EAST SEATTLE / BOYS & GIRLS CLUB PROPERTY vs COVAL PROPERTY (SUMMERWELL) vs

EAST SEATTLE / BOYS & GIRLS CLUB PROPERTY

Builders asking for 14 houses on 2.88 acres – Granted ?????

PRELIMINARY TREE RETENTION AND REPLACEMENT PLAN
2825 W MERCER WAY
PRELIMINARY PLAT
 PARCEL #2174502425
 CITY OF MERCER ISLAND WASHINGTON

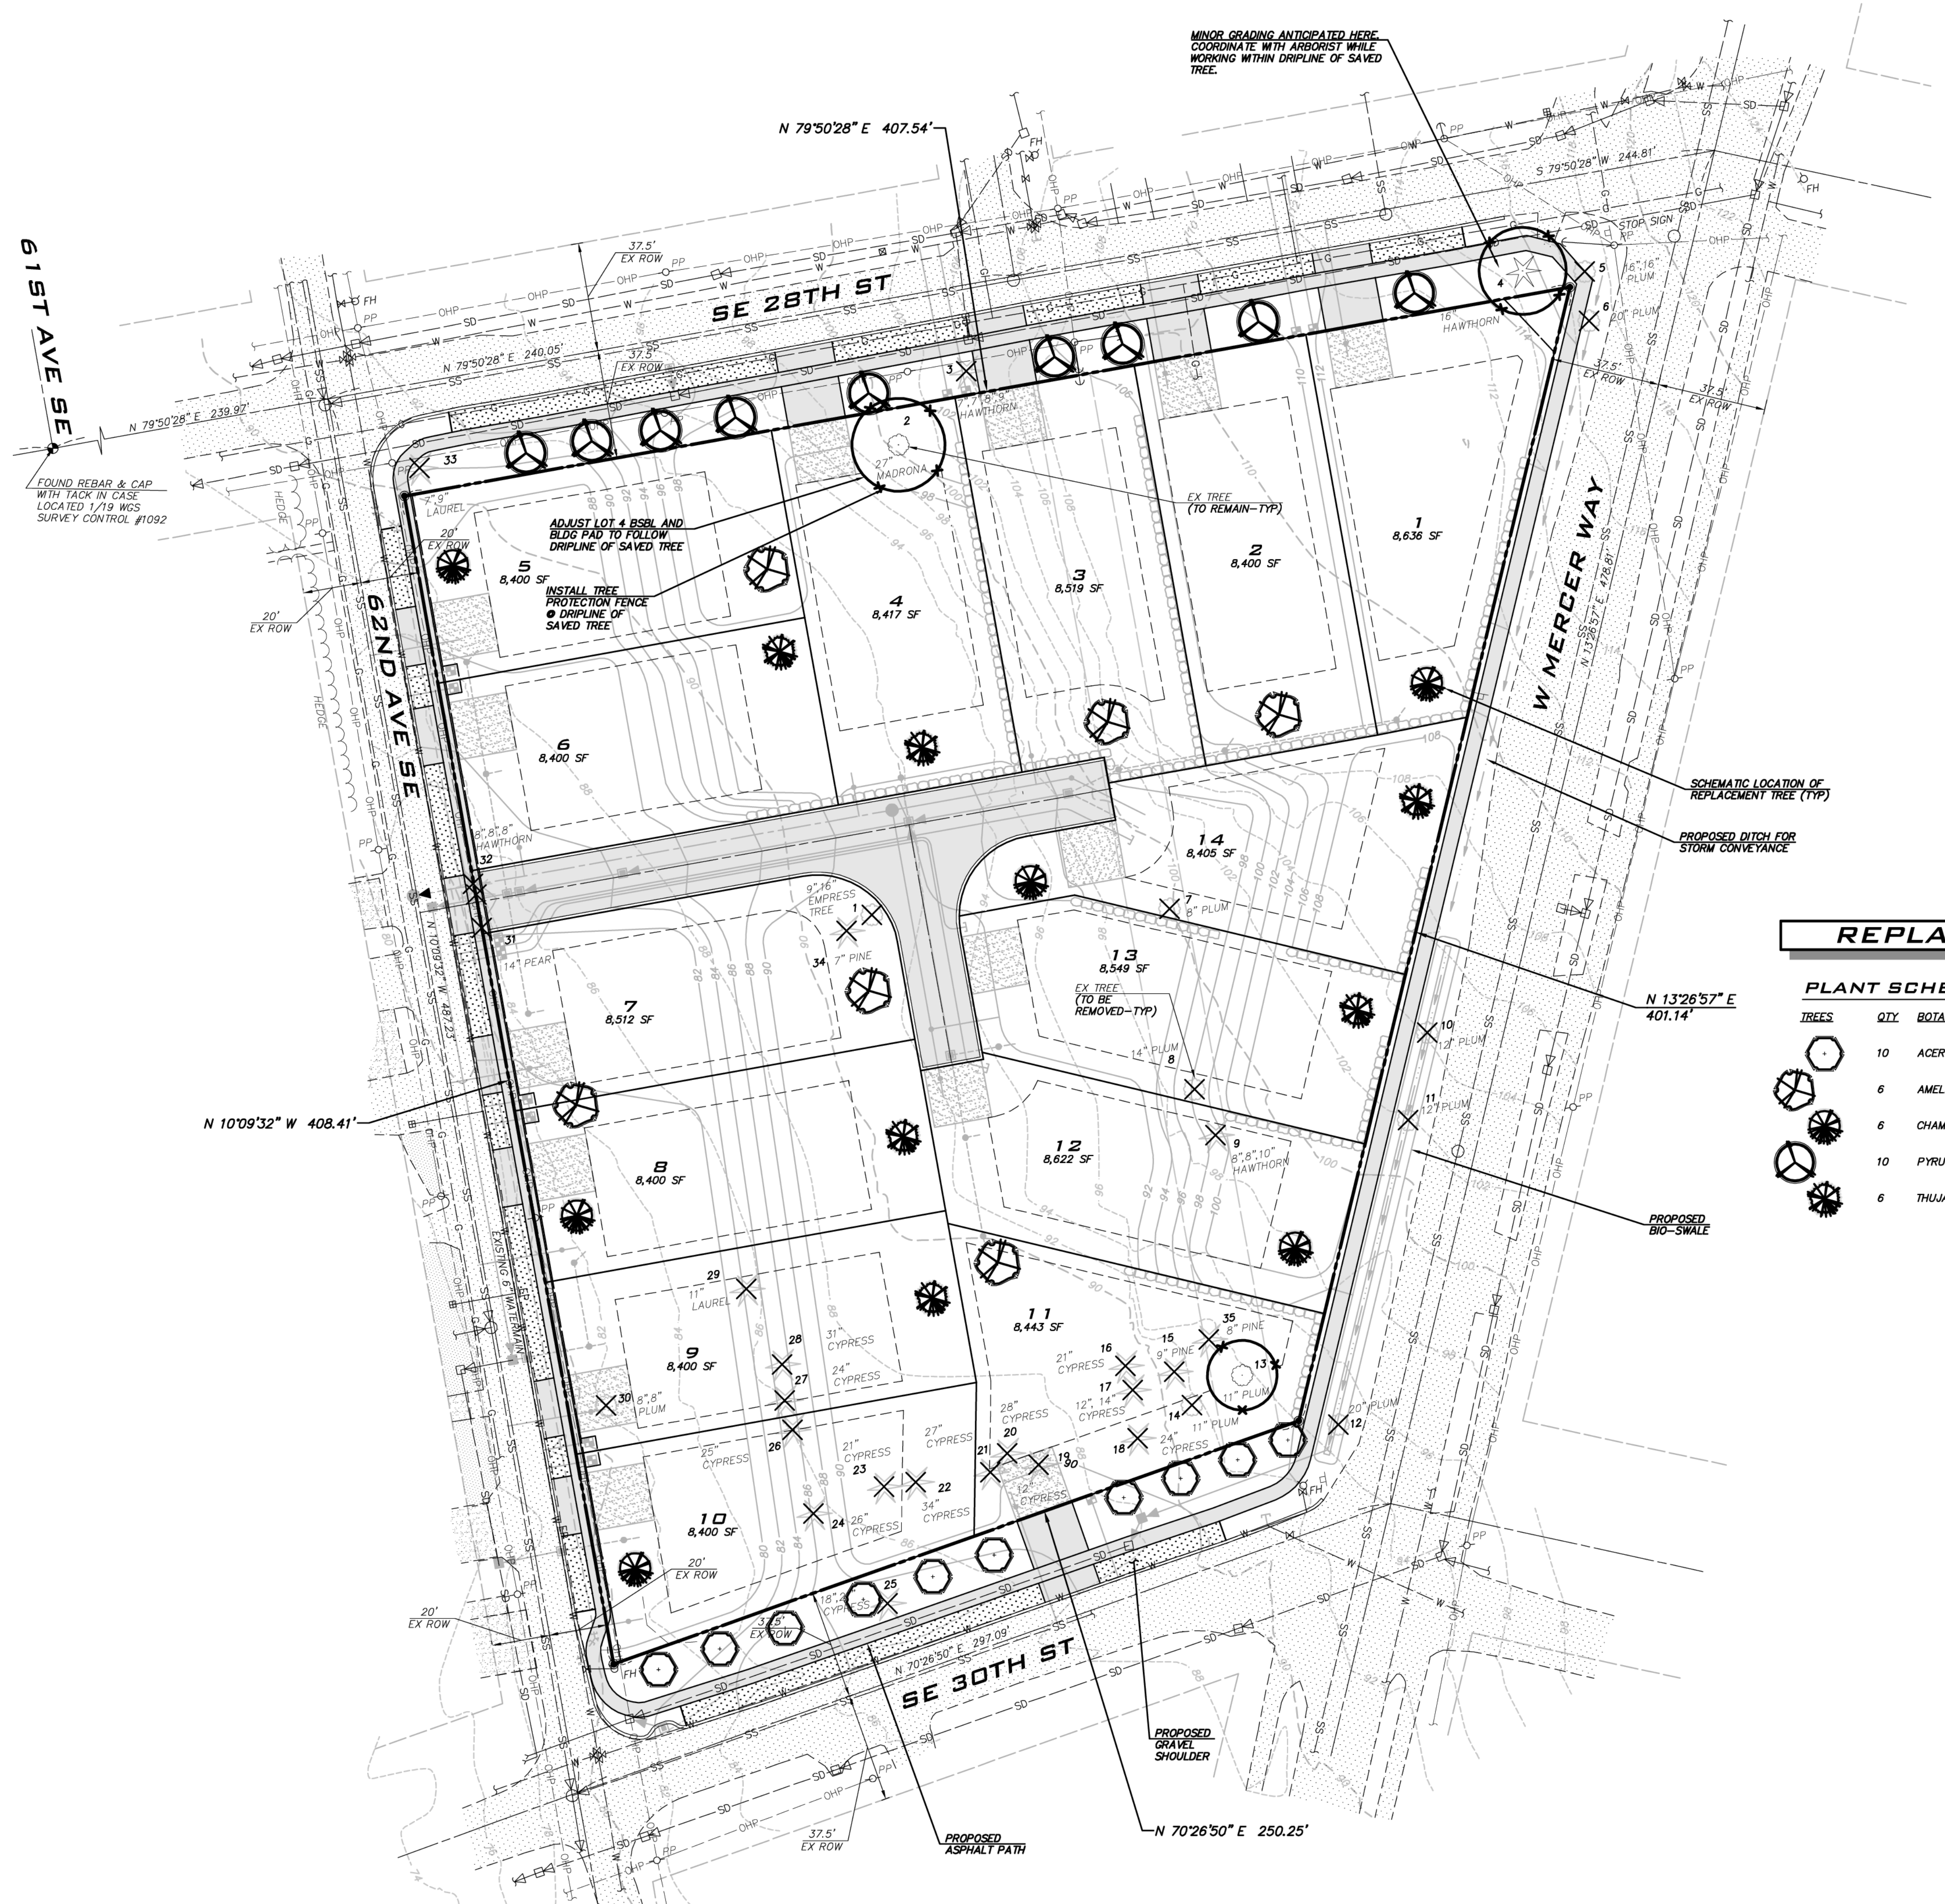
- More plants, green space to blend development into neighborhood. But plant dwarf varieties of trees not 100” evergreens that block people’s views
- Too many houses – Coval property development asked for 18 houses on 5 acres and were granted 16. These builders want 14 on 2.88 acres!
